From: PScan1
Subject: FW: 23/01195/LB Tower Farm, Station Road, Tower End, Middleton, Norfolk, PE32 1EE

RE: 23/01195/LB Application for listed building consent for proposed demolition of utility for new kitchen/lobby extension and glazed link, part conversion of outbuilding Tower Farm, Station Road, Tower End, Middleton, Norfolk, PE32 1EE

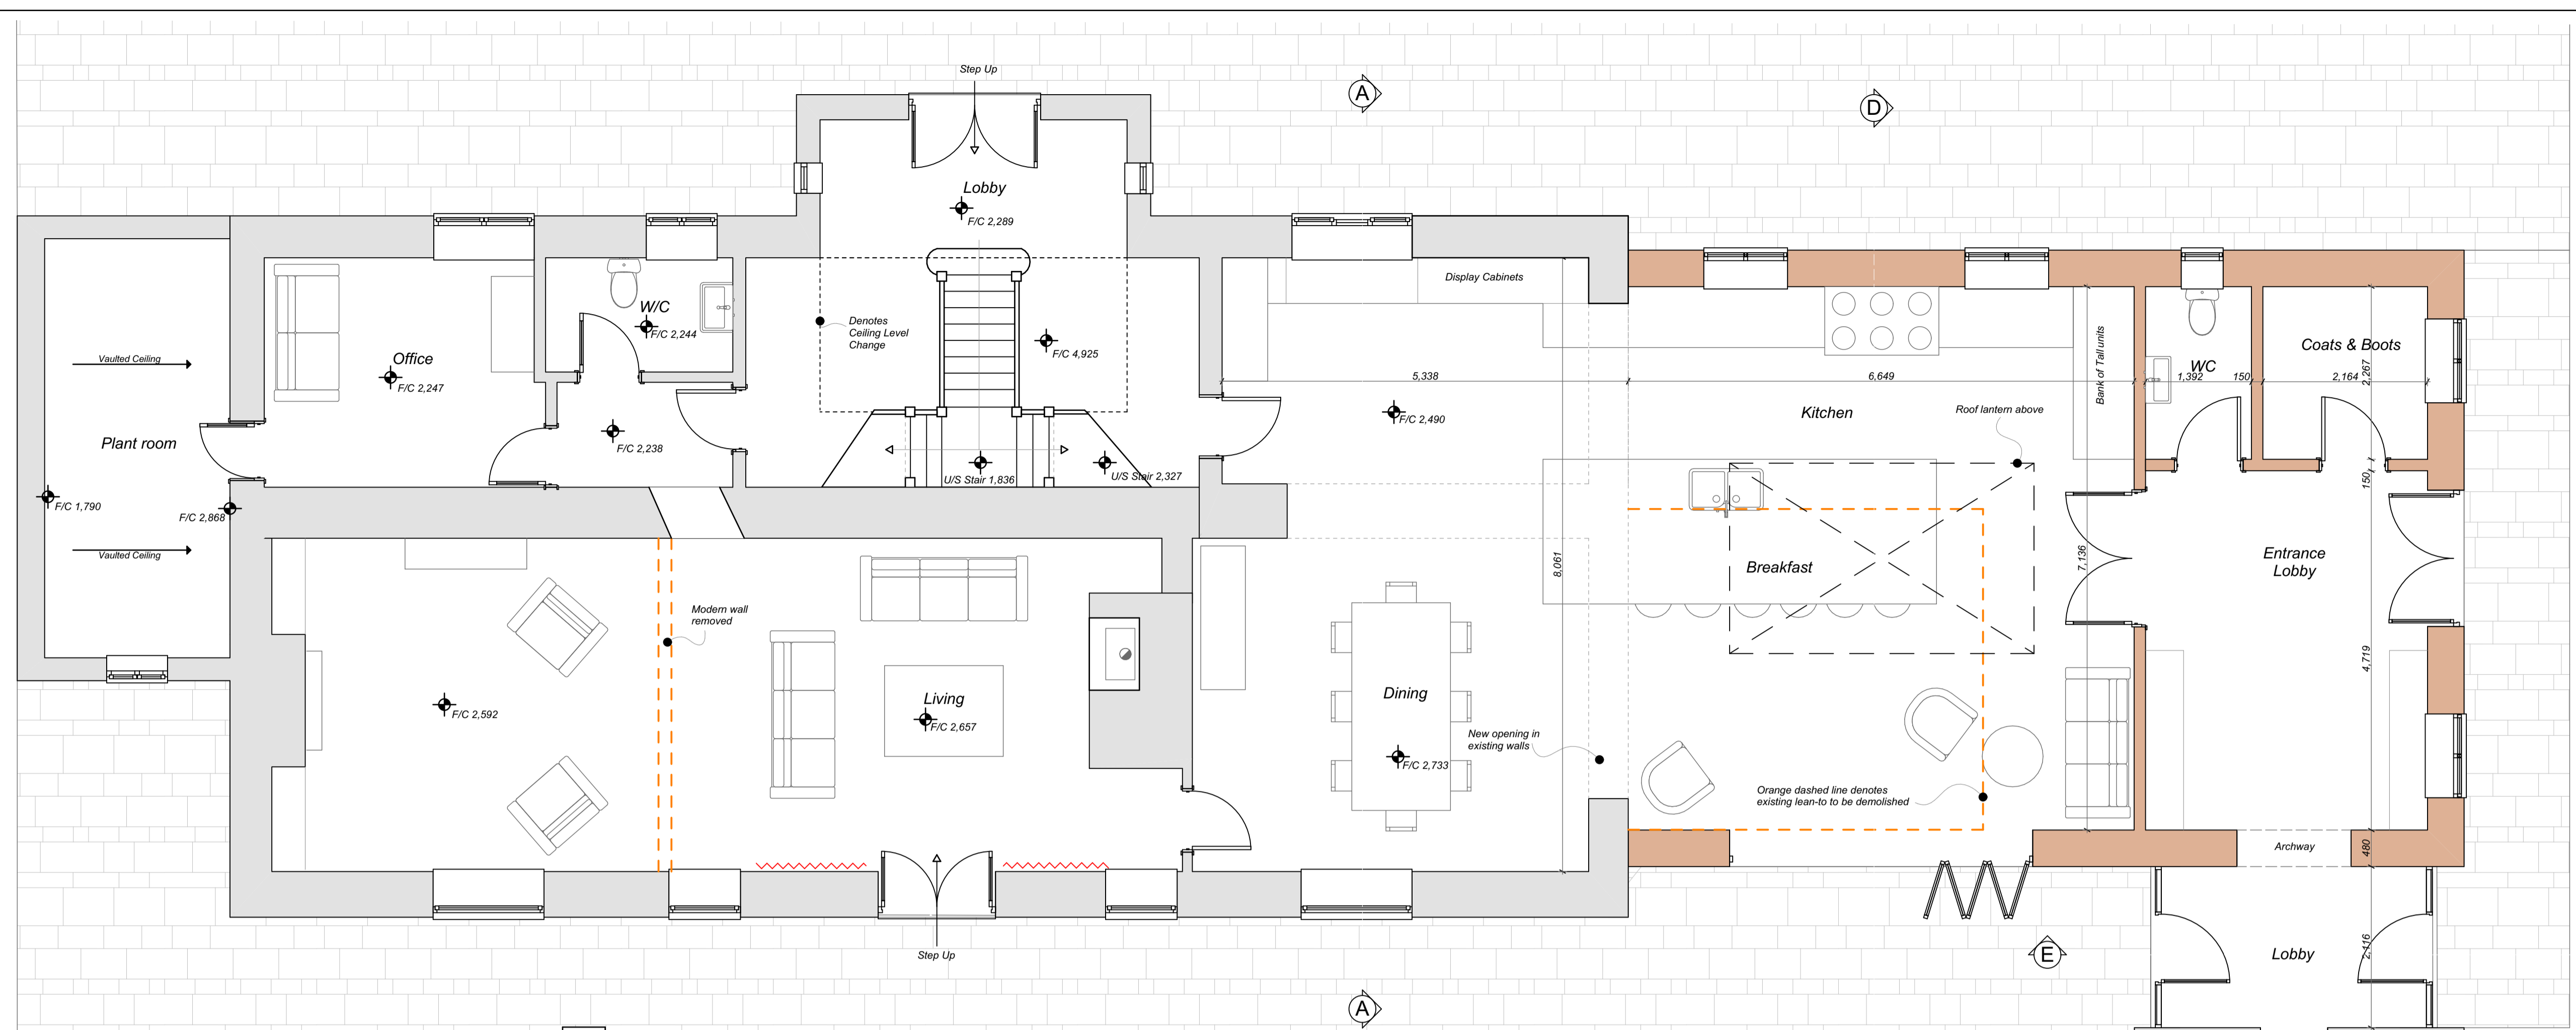
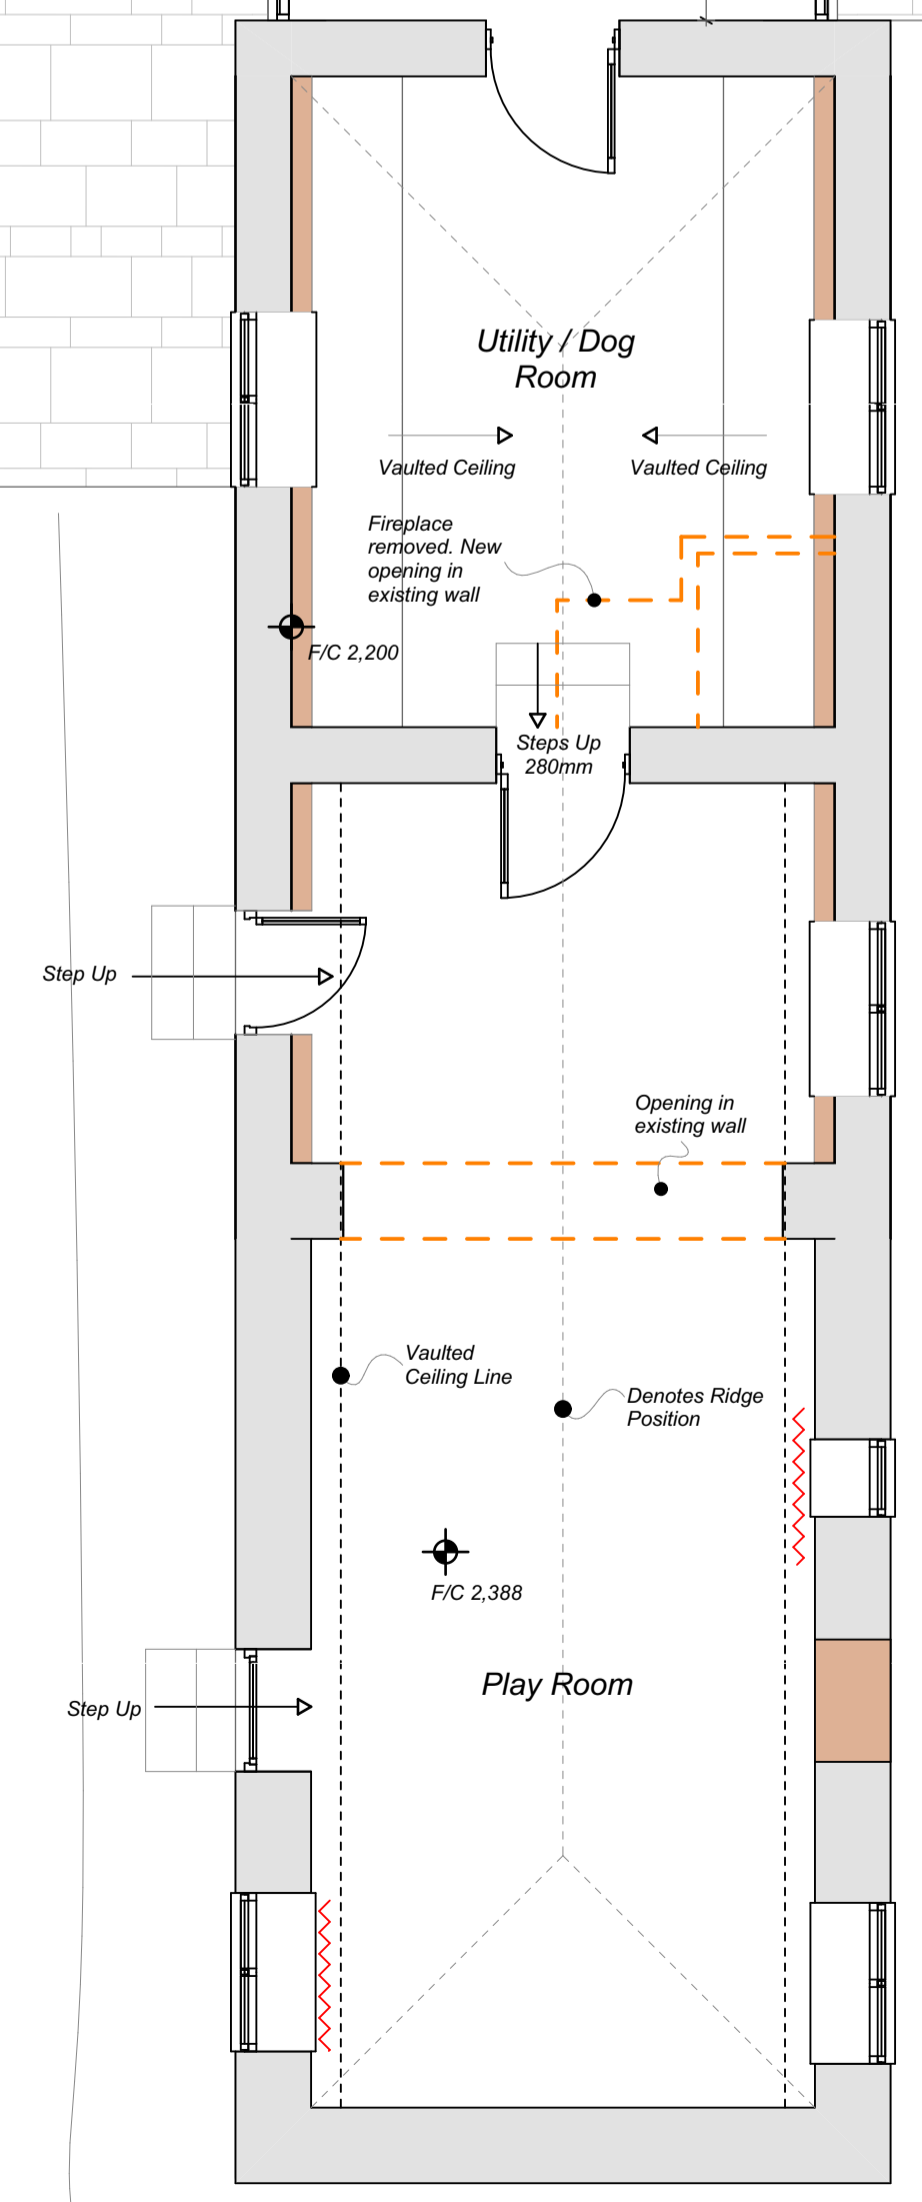
Tower Farm is a significant Grade II listed farmhouse dating from the C18 with C19 additions and alterations. Recent works to the building have removed much of the C19 interest of the building, but the small extension which forms the scope of these proposals is a notable C19 part of the building. It appears to retain historic glazing and the interior contains a fireplace and sink with handpump, these make a contribution to the evidential significance of the building, showing how the dwelling historically functioned. The extension also contributes to the legibility of the historic development of the building.

The demolition of this part of the building would harm the significance of the building by reducing its evidential value. The proposed extension would not deliver any discernible public benefits to outweigh the harm, the existing building is already a sizeable swelling.
